Review Response

Project Name: Seda Pier

Response To: Impervious Calculations Correction

This letter is in response to the corrections SHL23-015 and SEP23-004. Below are our responses to the questions/comments from 11/02/2023.

SHEET
17.0

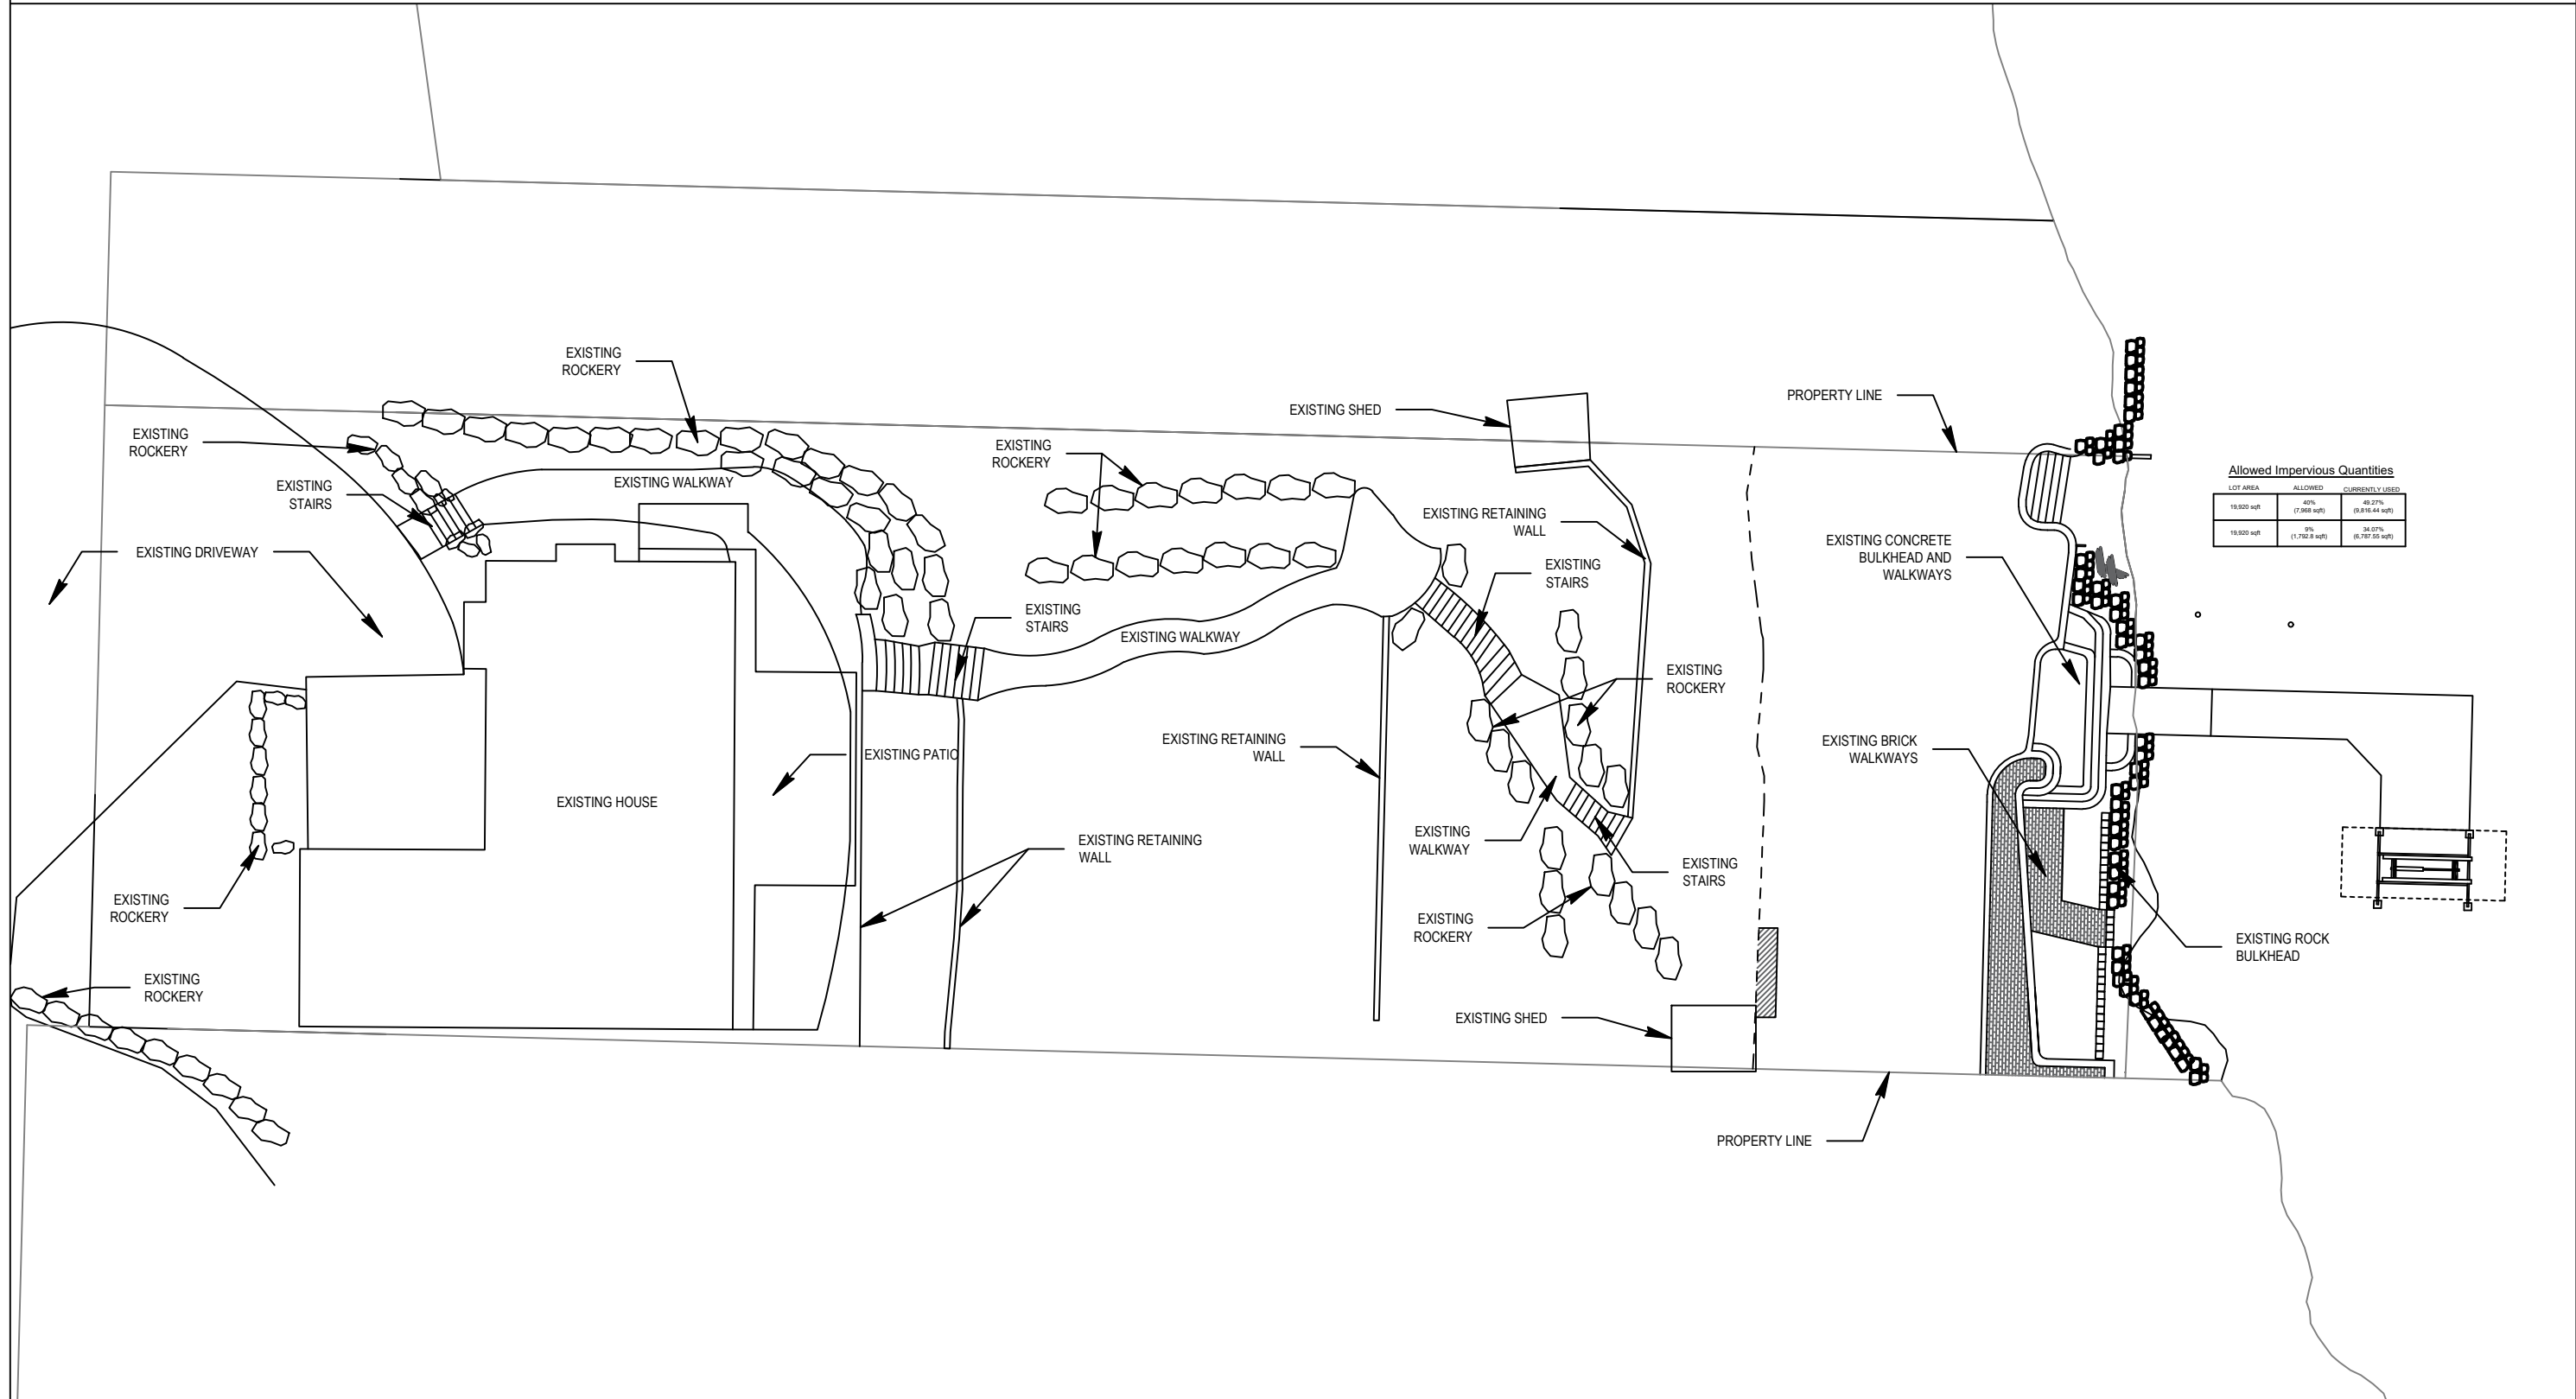
1. Site Hardscape calculations pages added for consistency with MICC 19.02.020(f)3)(b) this calculation demonstrates non-conformity of the existing hardscape which is legally established under Permit # 0902-010 on 3-19-2009. This nonconforming hardscape may continue per 19.13.020(a). The portion of the hardscape falling under our proposed work complies with 19.01.050(F)(1) Non-conforming sites – The existing hardscape to be reallocated to the cove outside of the existing footprint results in a net loss of more than 2 sqft of hardscape for every 1 sqft of hardscape relocated.
2. MICC 19.02.060 does not apply and will not be used as code compliance reference.

Please see the attached plan set with update code reference pages demonstrating compliance with the above cited codes.
